Your Ref: OWPC19859
Our Ref: EG/49/18/OUT 03-07-2018
Please ask for:
Michael Eastham

Outline application with some matters reserved for the demolition of 1 No. dwelling & erection of 10 No. new dwellings, widening of existing access to provide improved visibility splays, maintaining front boundary buffer of approximately 5m in depth, car parking for 30 cars (including garages and visitor parking) & landscaping.

Bexstone House Barnham Road Eastergate

Thank you for your internet representation made on 1st September 2018 which has been recorded as **'no objection'** with the comments as follows:

Drawing Title
Proposed Access Visibility Splays Realignment

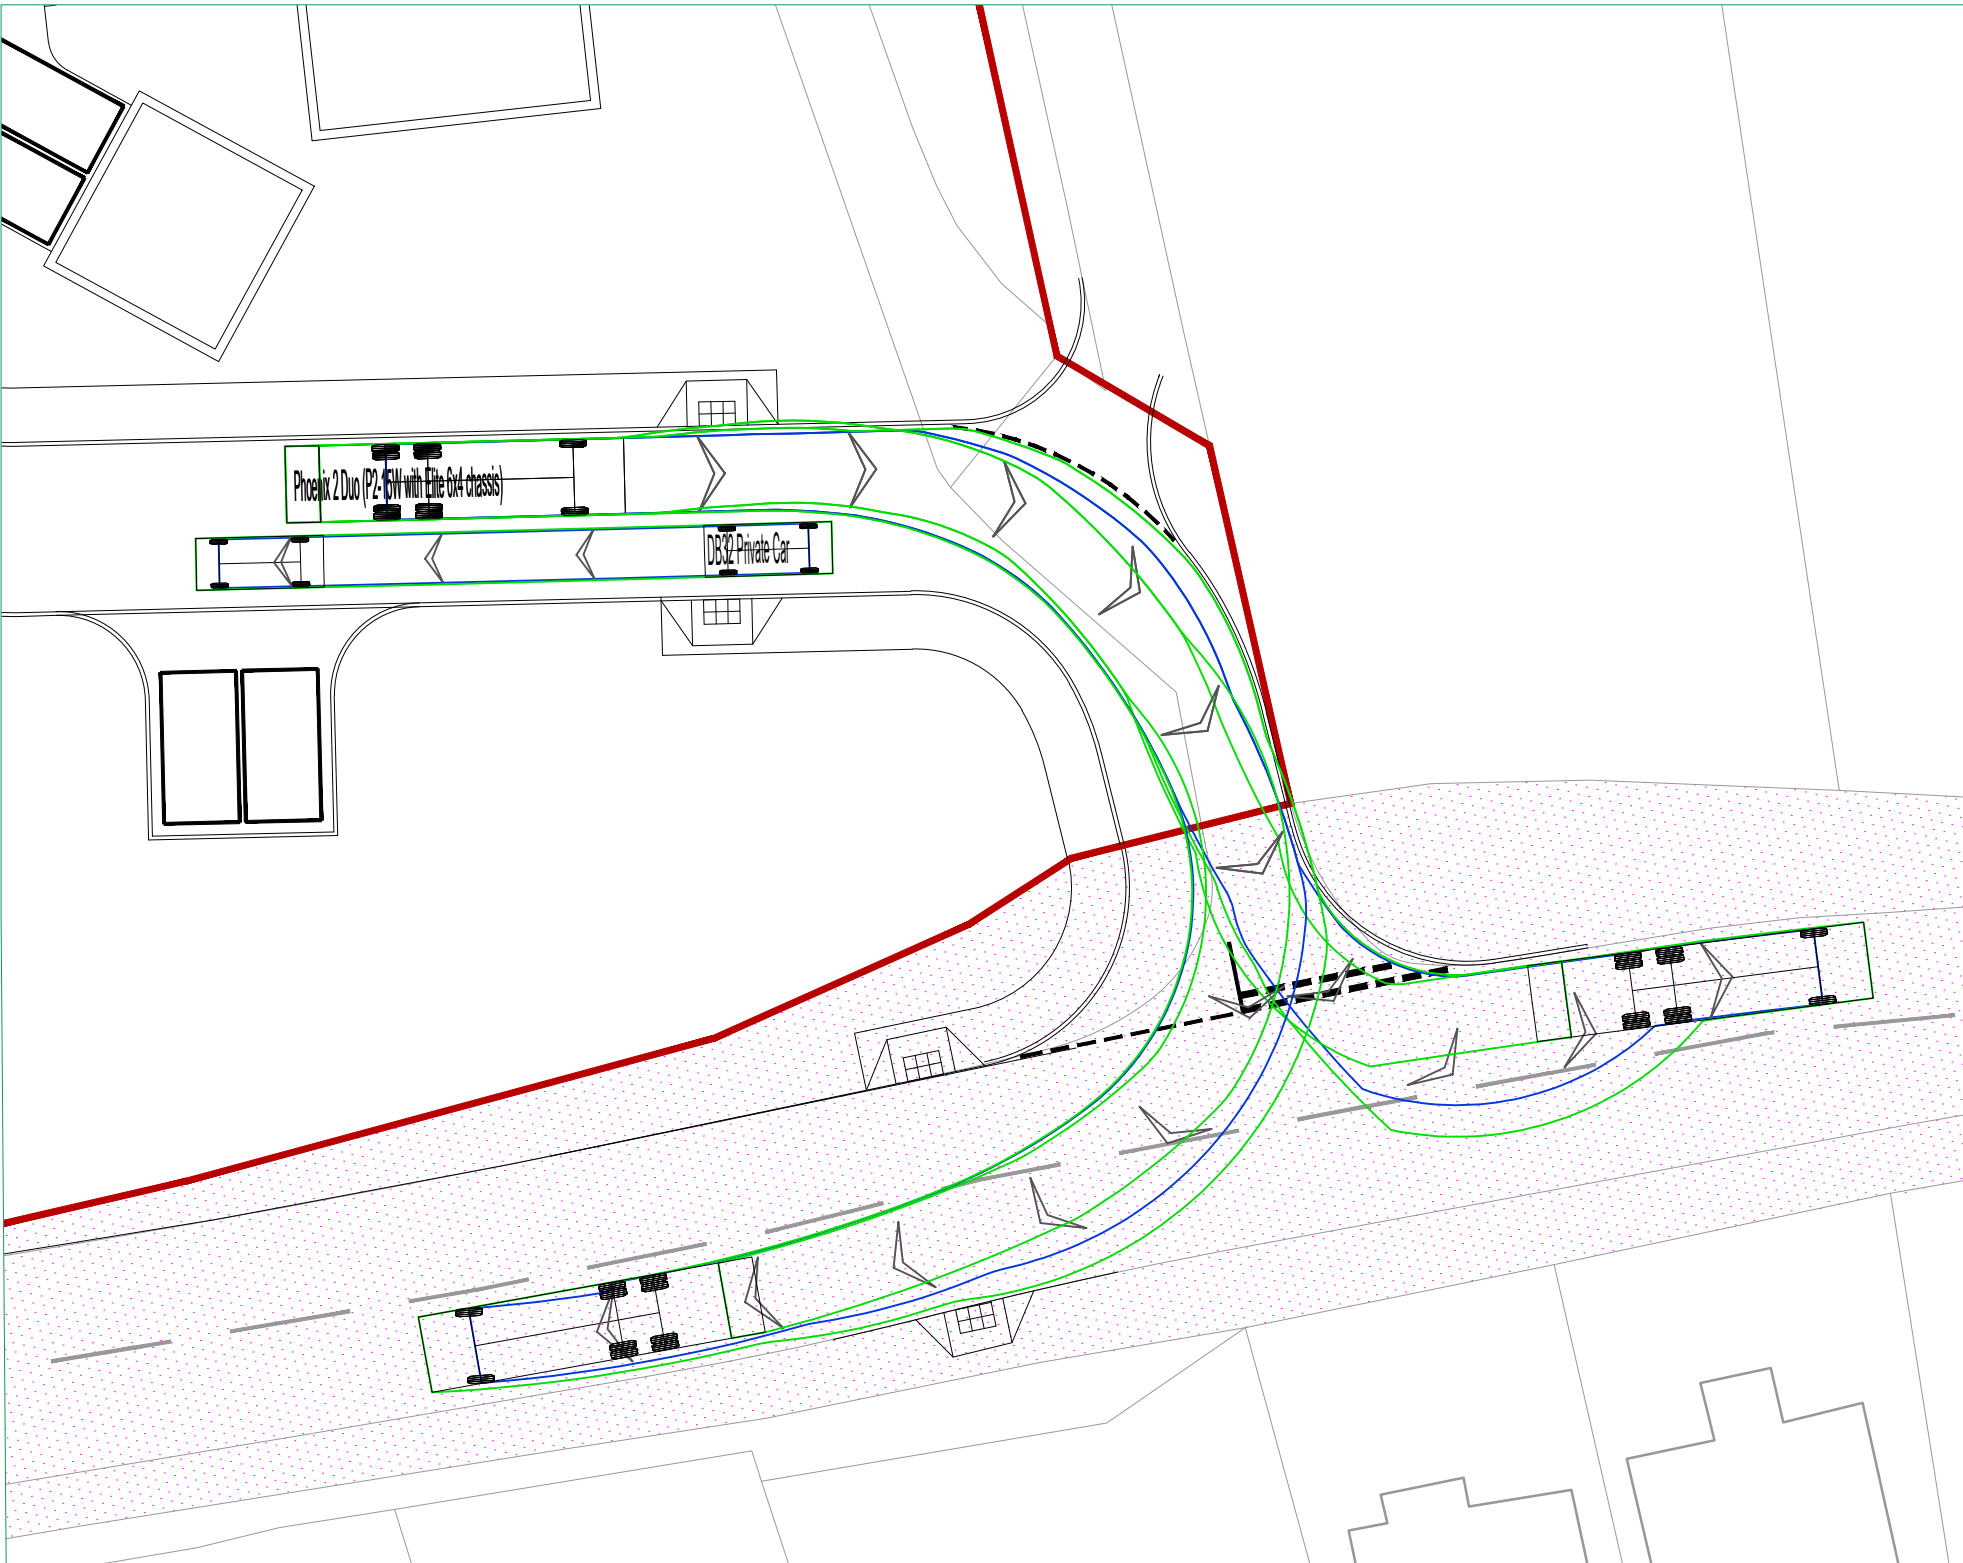
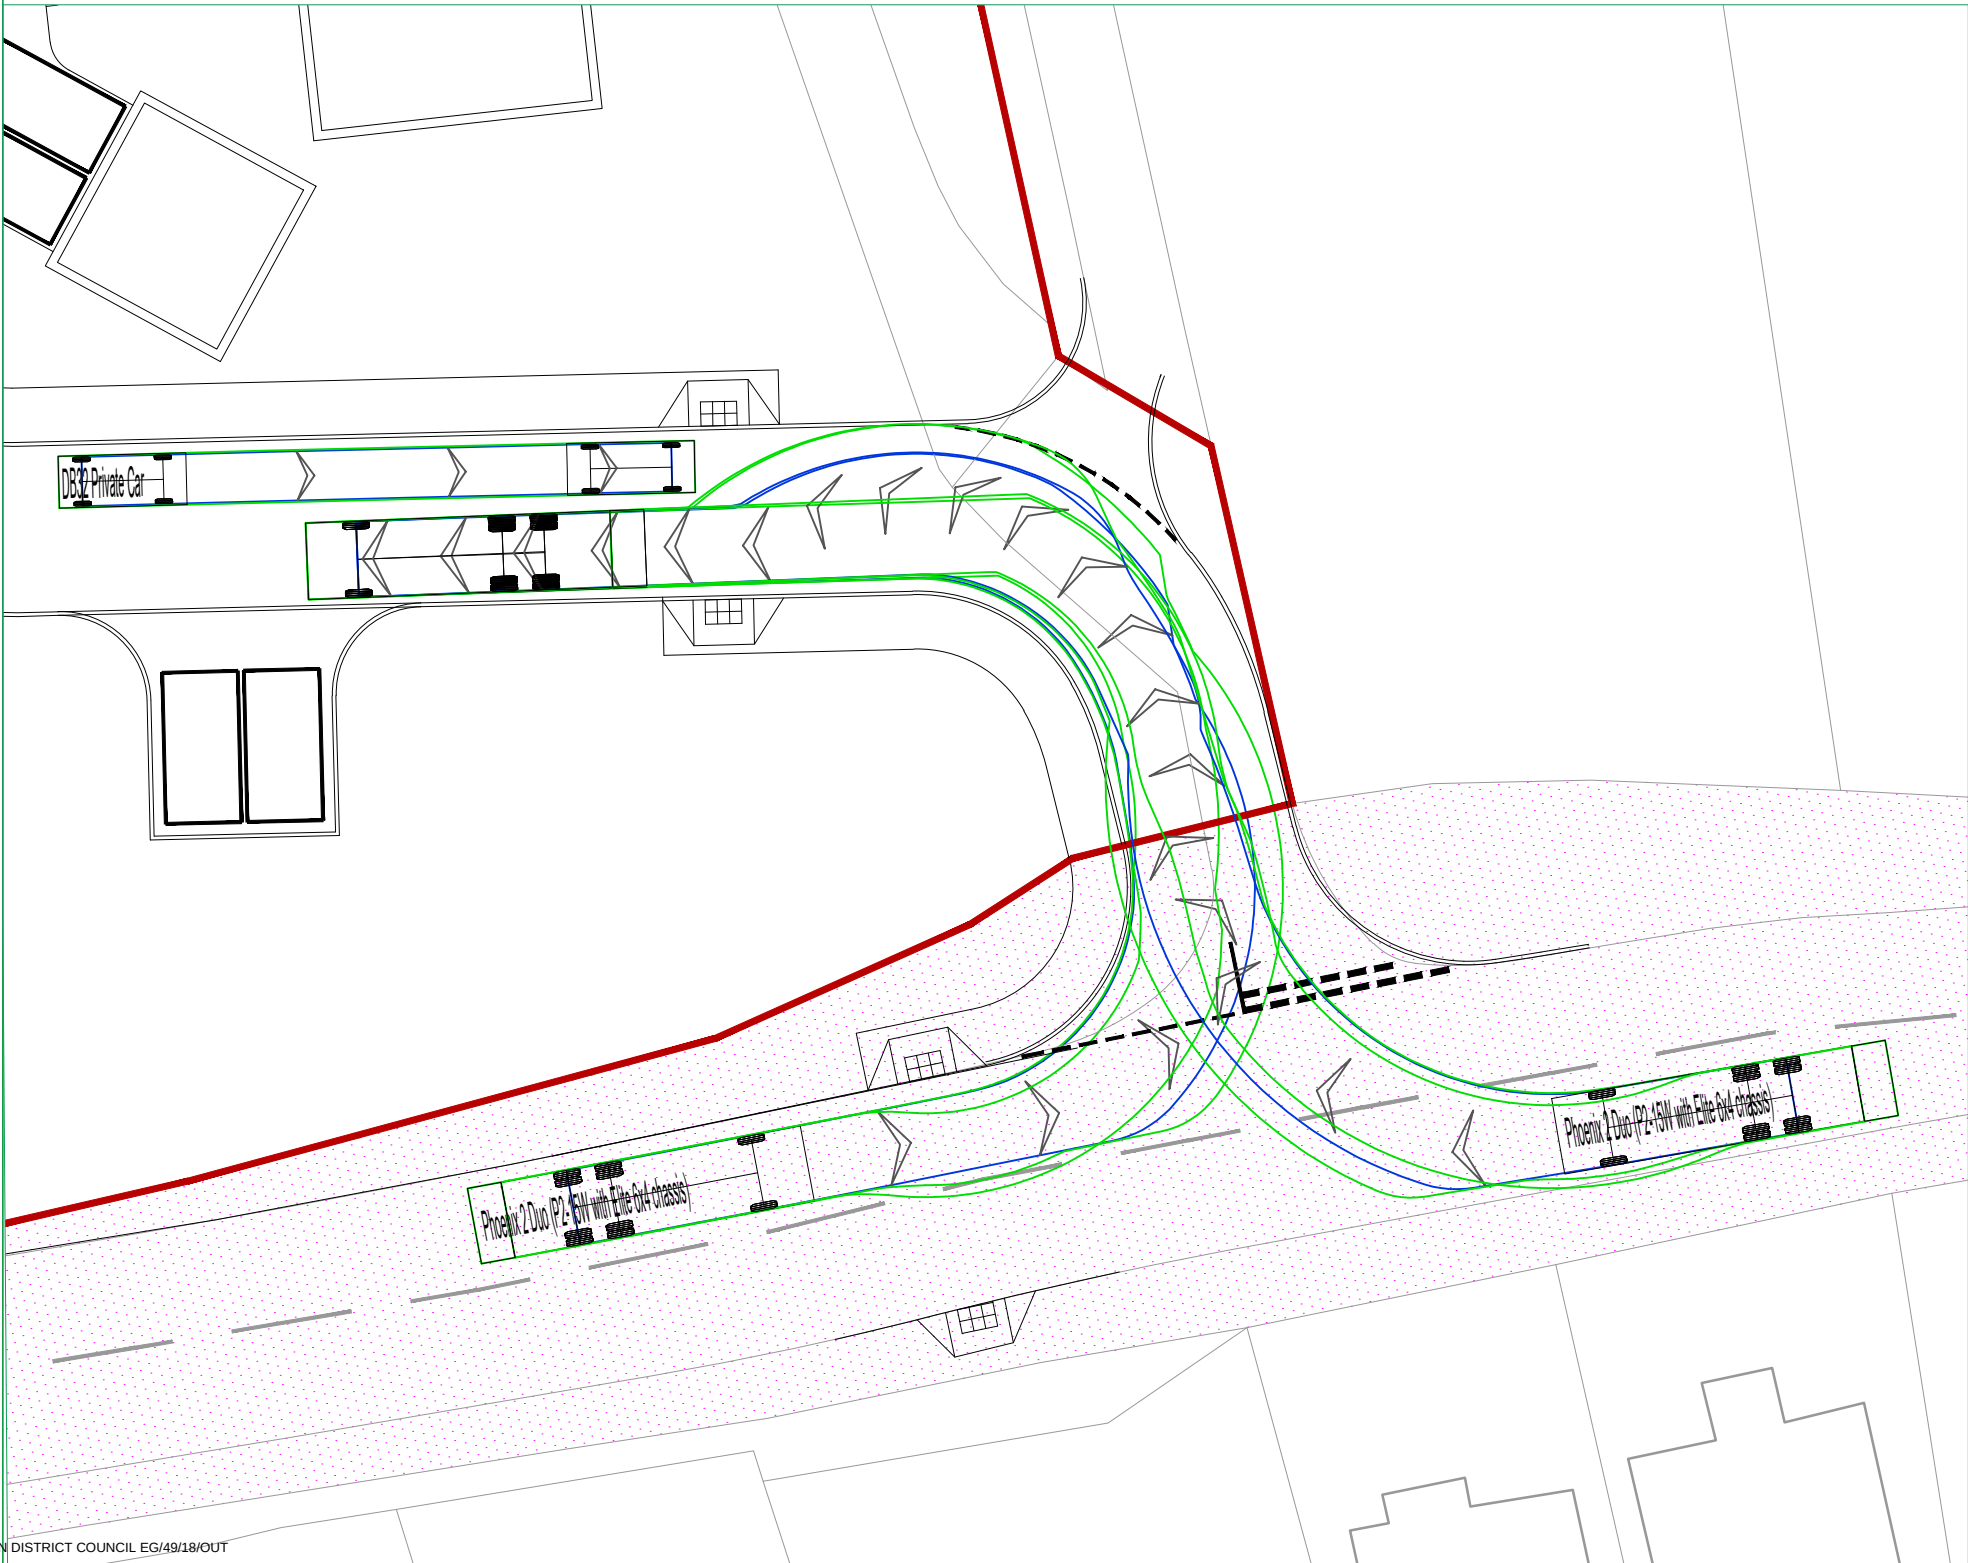
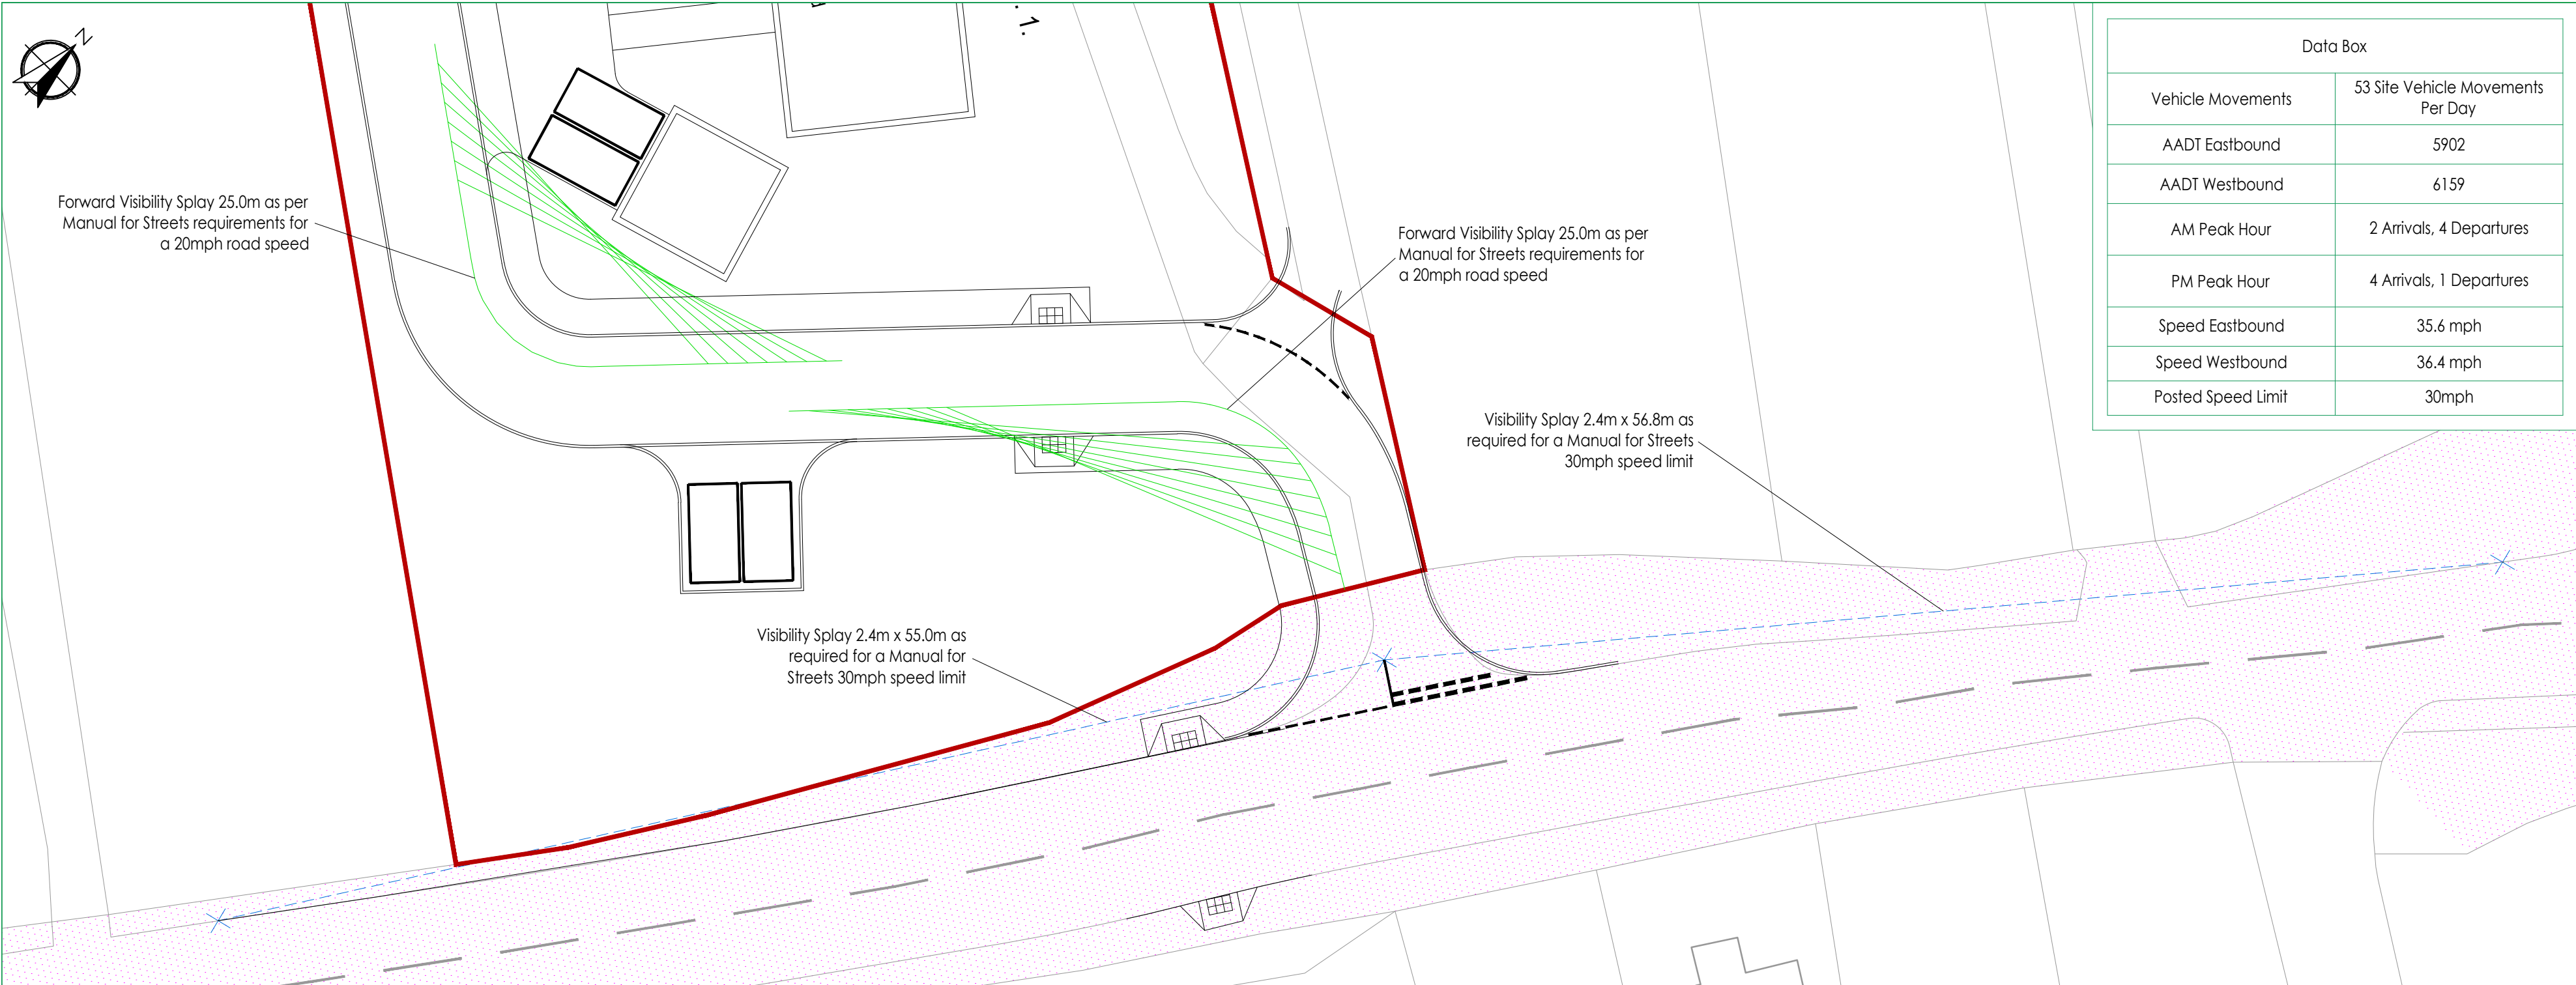
- *Safety and Traffic - Kinnersley has right of access to the B2233 highway over the first section of Bexstone driveway. Kinnersley uses oil fired heating and requires regular oil tanker deliveries to the rear of Kinnersley site. The proposed road changes alter the access angles to Kinnersley drive way making it impossible for the oil tanker to enter Kinnersley drive without driving across the new kerbs and/or Kinnersley lawn and garden. The proposed road layout needs to be revised to permit easy and safe oil tanker access to Kinnersley.*
